Tel: 01895 250230
Case Officer: Michael Gavin
Email: MGavin@hillingsdon.gov.uk
Date: 12th July 2021
Our Ref: 40711/PRC/2021/102

RE: Amendment to roof and building levels and reduction in density from 2 x 3 Bedroom and 4 x 2 Bedroom flats as previously approved under 40711/APP/2018/4033 to 4 x 3 Bedroom flats & 1 x 2 Bedroom flats

SITE: 27 Ducks Hill Road Northwood

PROPOSED FRONT/WEST ELEVATION

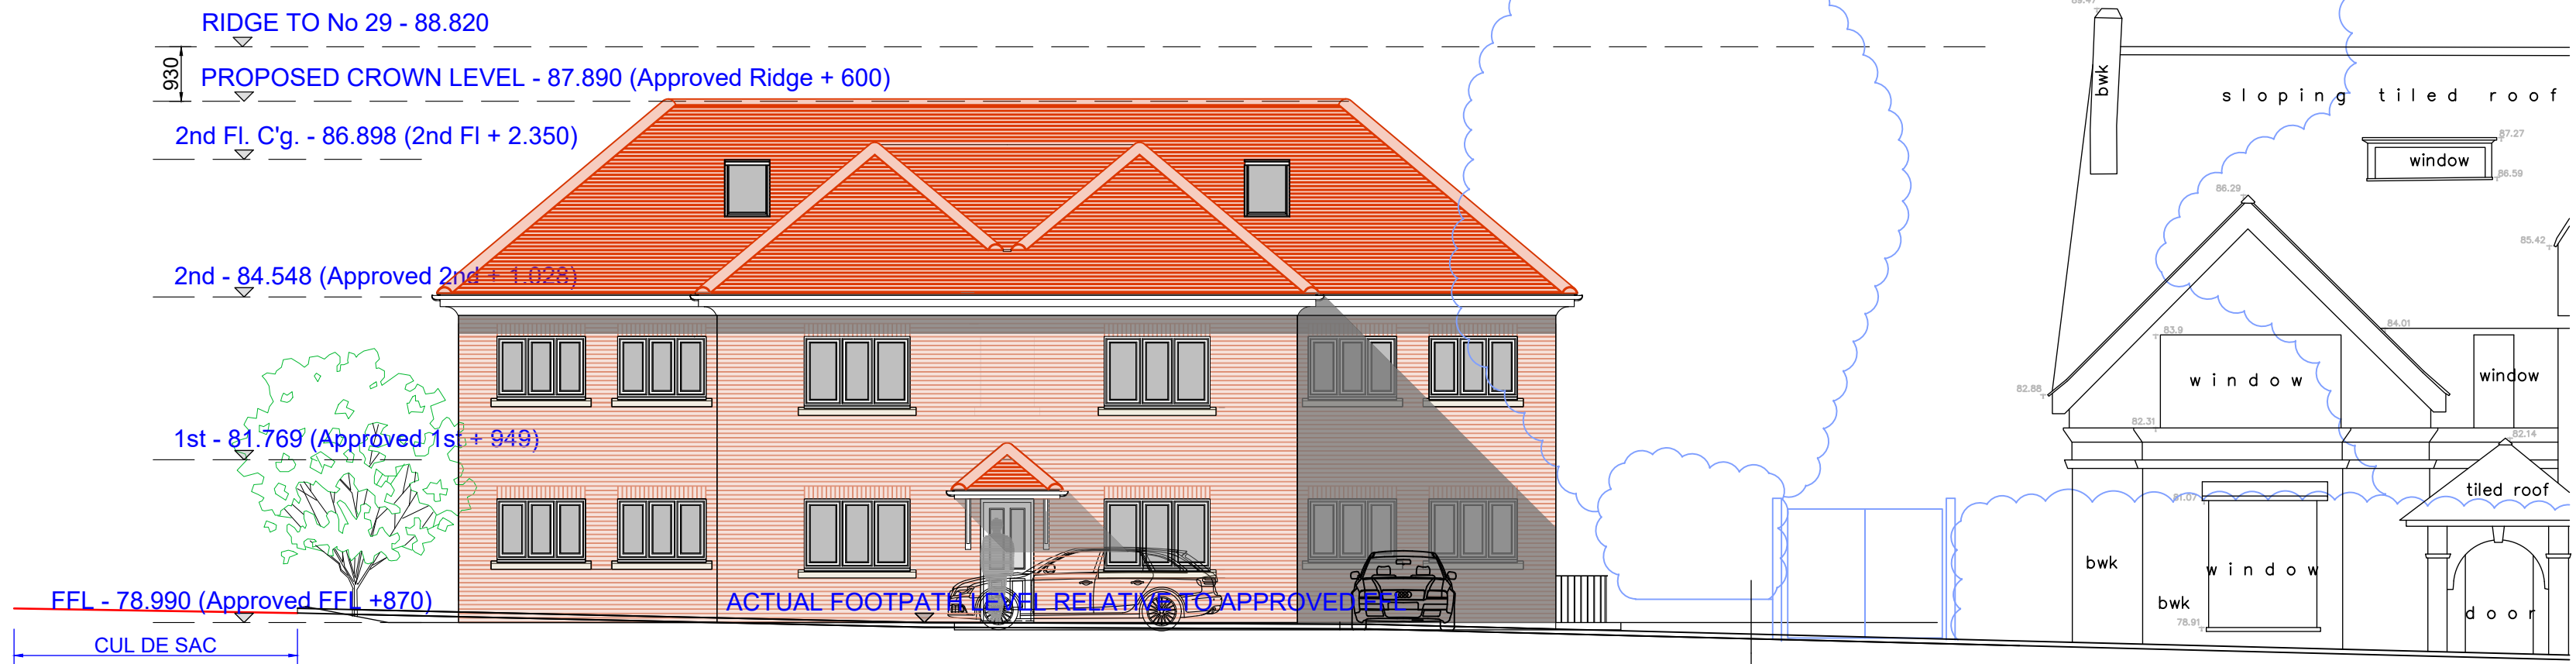
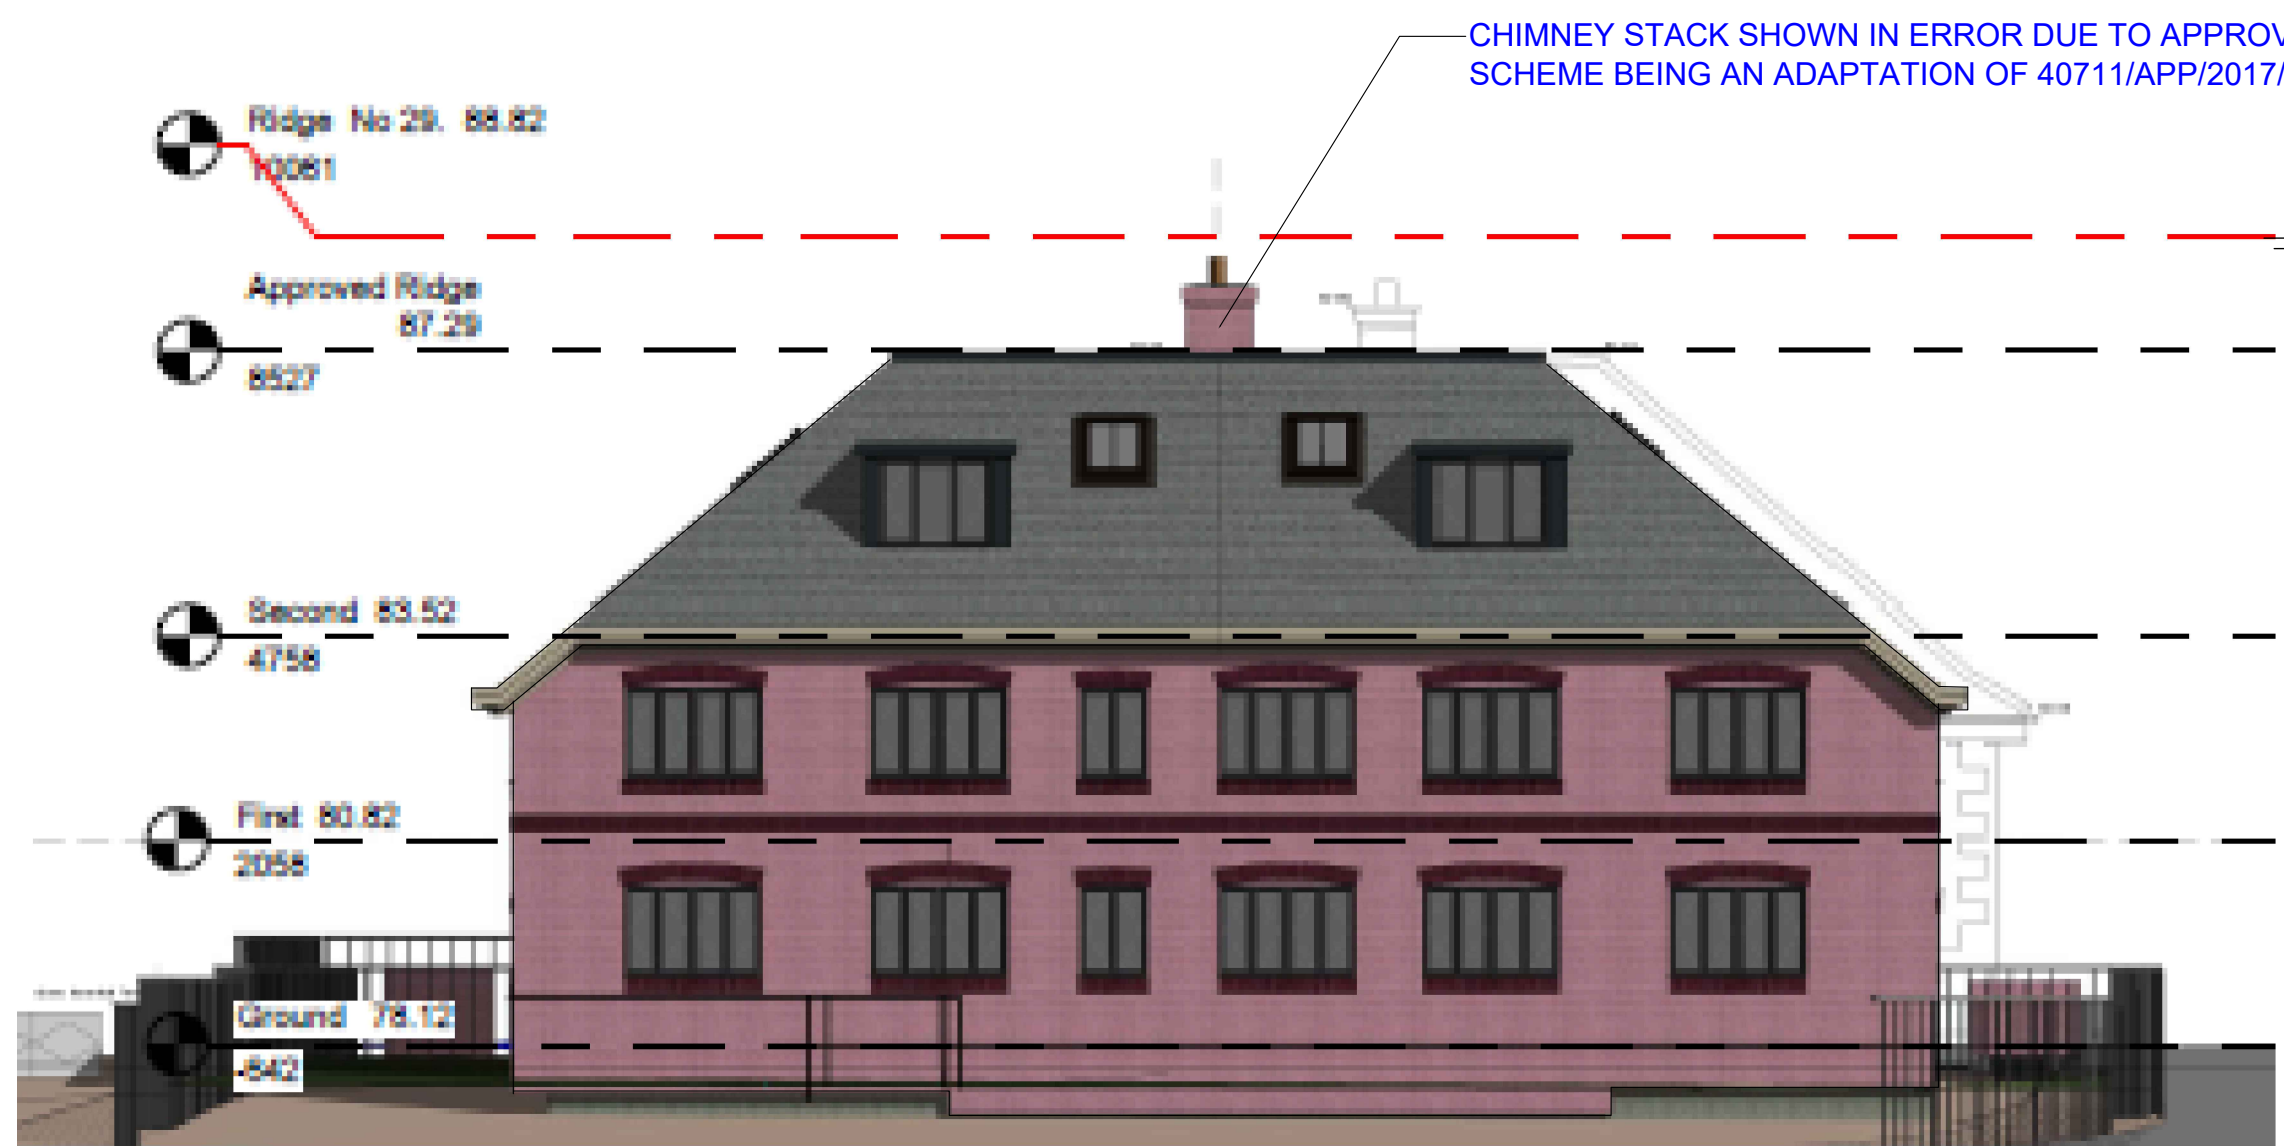
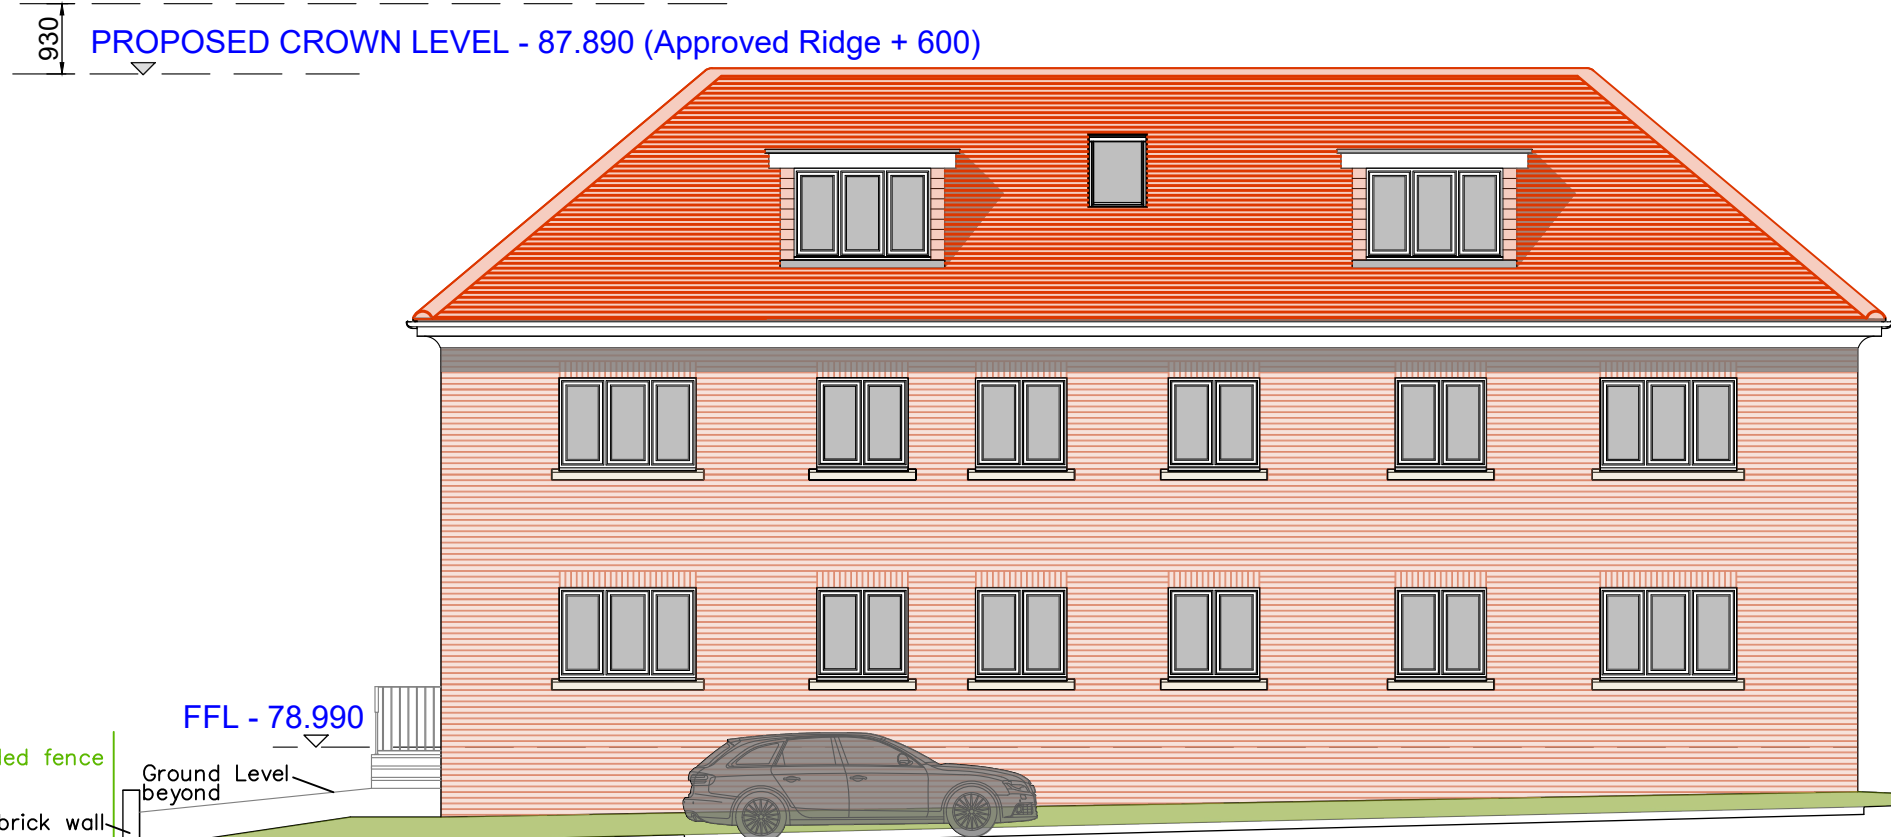
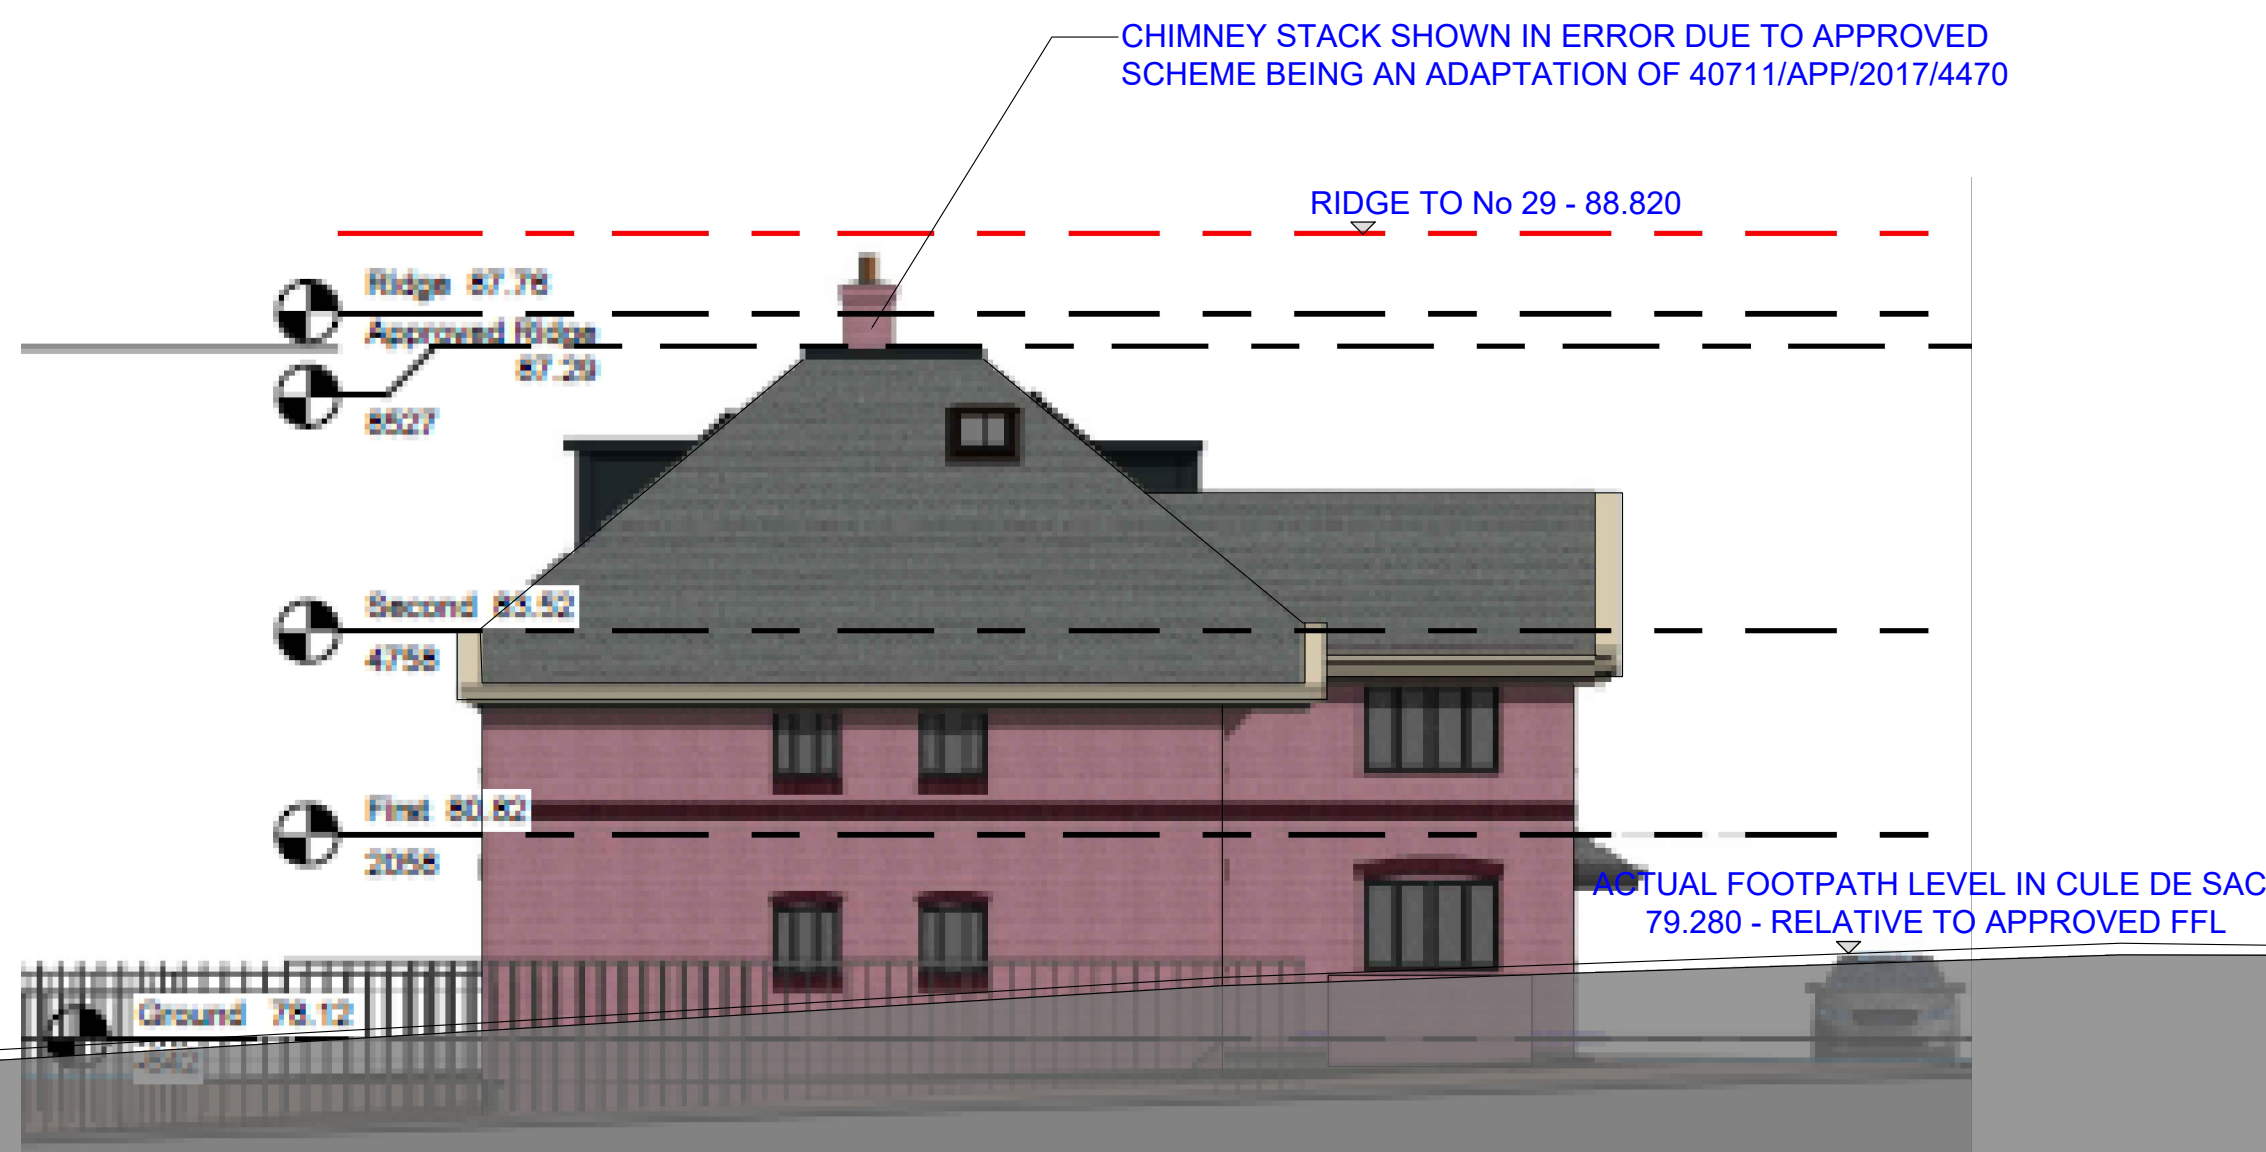
- omitting central front dormer
- adding design detail to twin-gabled projection front elevation
- increasing the height of the roof relative to building below, while still keeping the roof height 0.93m below that of 29 Ducks Hill Road, to address the issues raised of a somewhat squat appearance

I consider these changes improve the building's appearance compared to that of the building refused under application ref. 40711/APP/2021/519, by reducing the relative bulk and massing of the roof form above the projecting front element. I remain somewhat concerned, however, that compared to the scheme approved under application ref.

40711/APP/2018/4033 the scheme as amended remains a less attractive building, by virtue of the loss of the overhanging eaves and bulky elevations. As discussed there appears to be scope to reduce the top floor flat in size and still remain in excess of the required GIA for this unit. I appreciate the reasons given in terms of head heights and usability but you may wish to explore further any possibility of further reducing the extent of crown roof over the front projection.
